Date: 30 January 2023

**Re: Installation of a "private-wire" electricity cable between the Energy Centre, Tewin Road and Colt Technology Services Group Limited (Option 1). | 20 Black Fan Road Welwyn Garden City AL7 1QA**

## **ARCHAEOLOGICAL IMPLICATIONS**

Title:
Proposed Cable Route Option 1

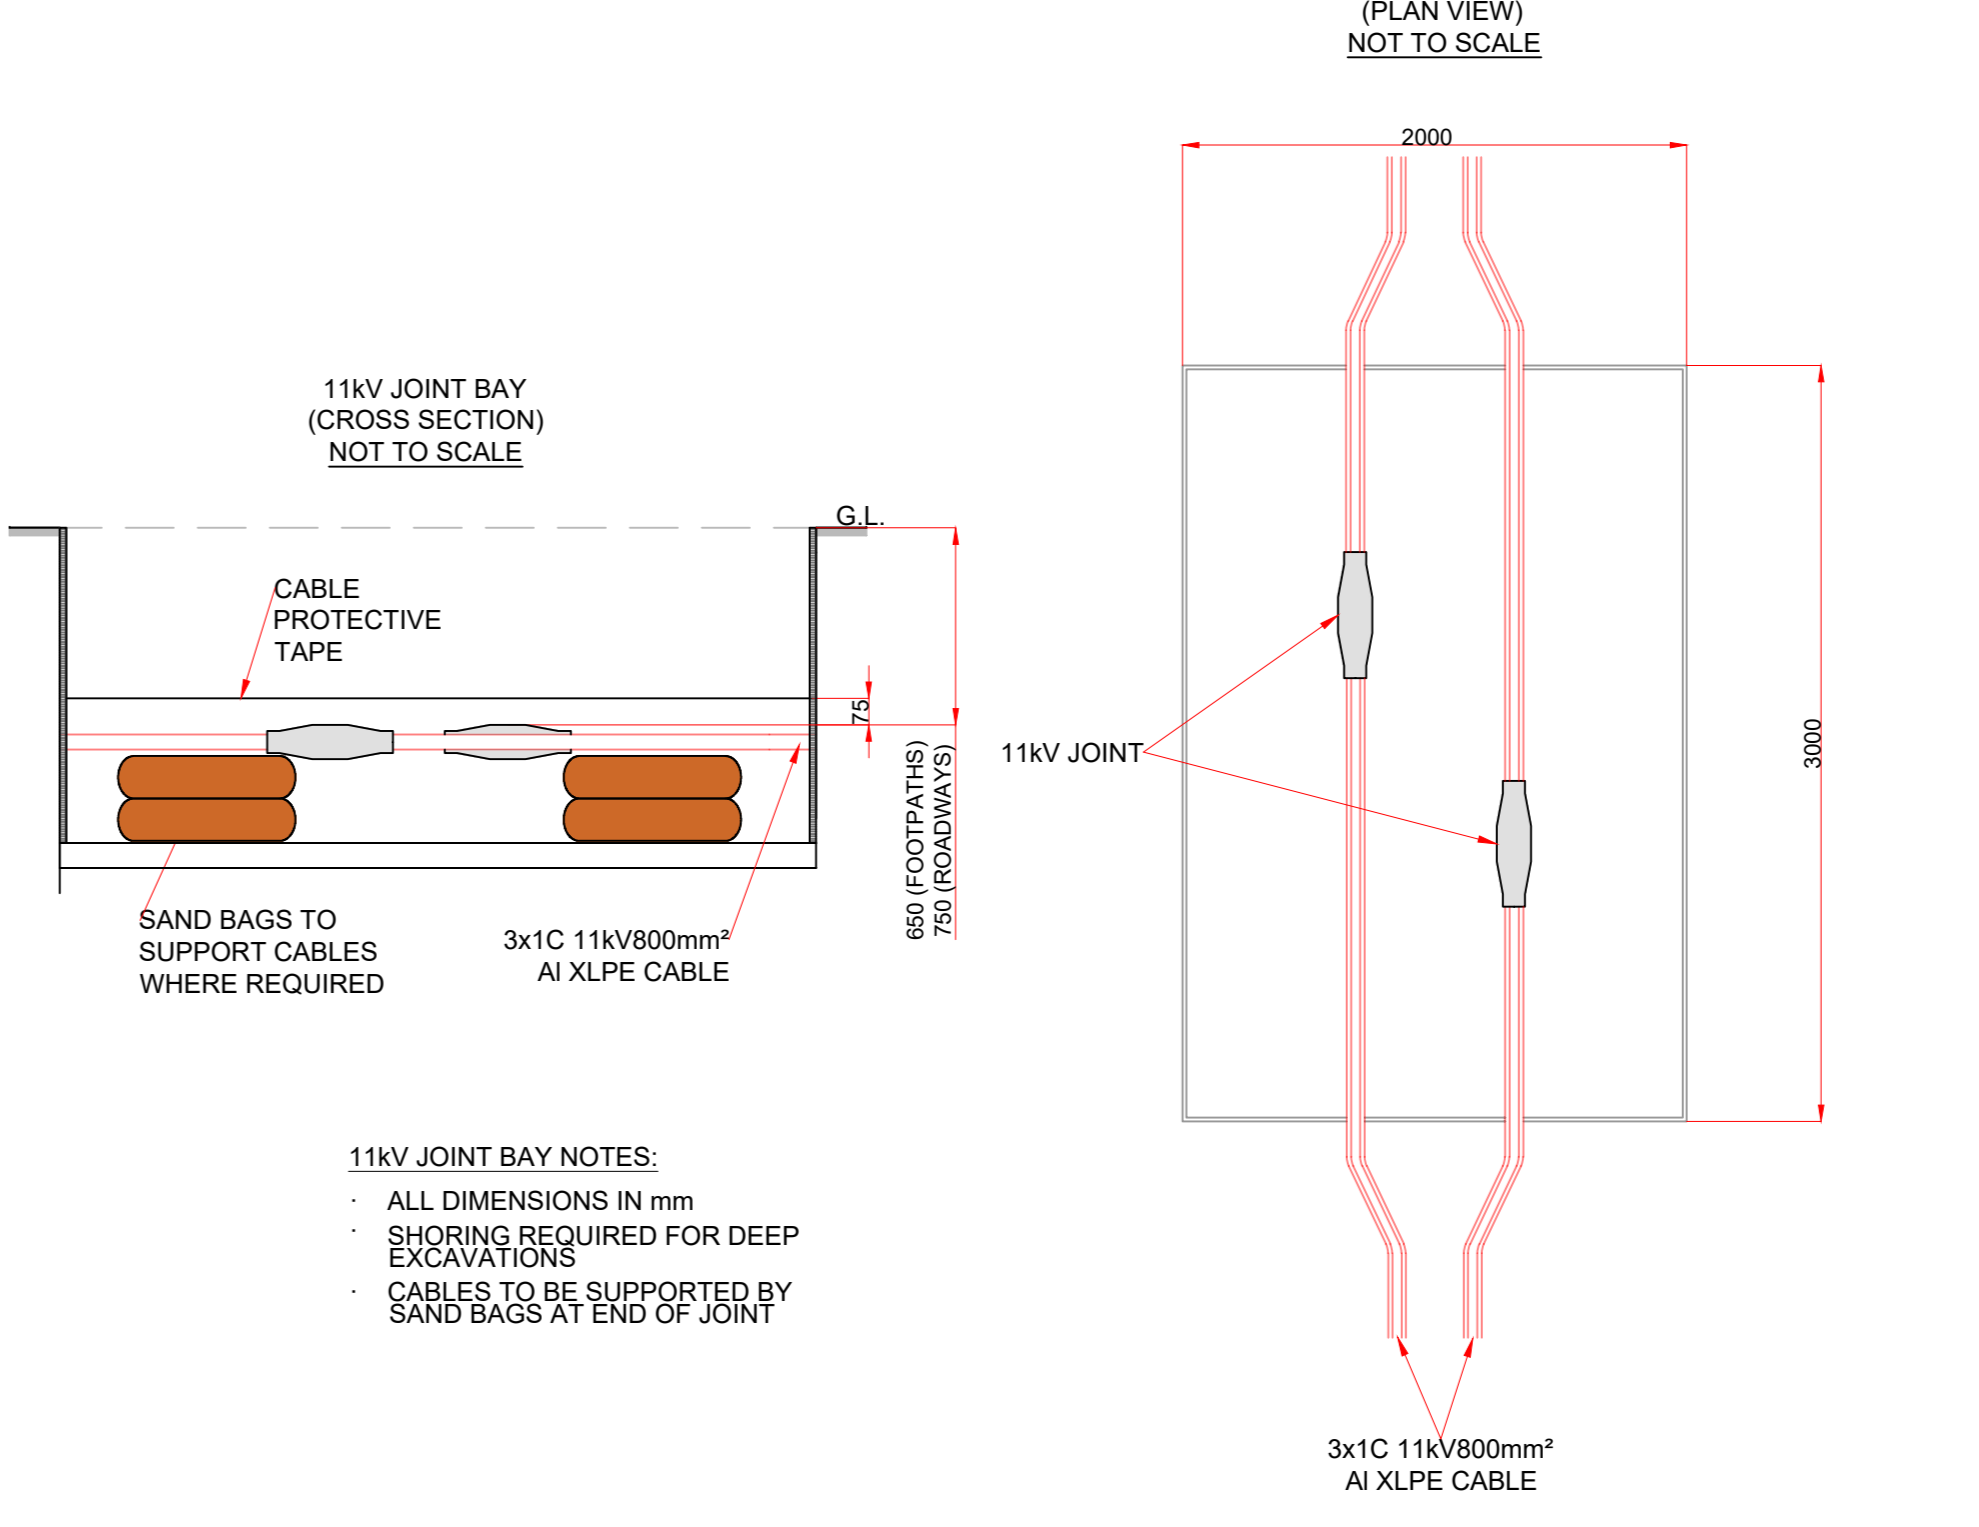
However, in some places it is possible that there will be an impact on the historic environment. For example, the historic environment record (HER) notes that at Hens Wood part of the proposed route may cross the remains of a low bank topped with ancient coppice which runs along the historic boundary between the parishes of Hatfield and Tewin and may represent an ancient boundary (HER17711).

We therefore believe that the proposed development is such that it should be regarded as likely to have an impact on heritage assets of archaeological interest and we recommend that the following provisions be made, should you be minded to grant consent:

**A** *No demolition/development shall take place/commence until an Archaeological Written Scheme of Investigation has been submitted to and approved by the local planning authority in writing. The scheme shall include an assessment of archaeological significance and research questions; and:*

**B** *The demolition/development shall take place/commence in accordance with the programme of archaeological works set out in the Written Scheme of Investigation approved under condition (A)*

**C** *The development shall not be occupied/used until the site investigation and post investigation assessment has been completed in accordance with the programme set out in the Written Scheme of Investigation approved under condition (A) and the provision made for analysis and publication where appropriate.*
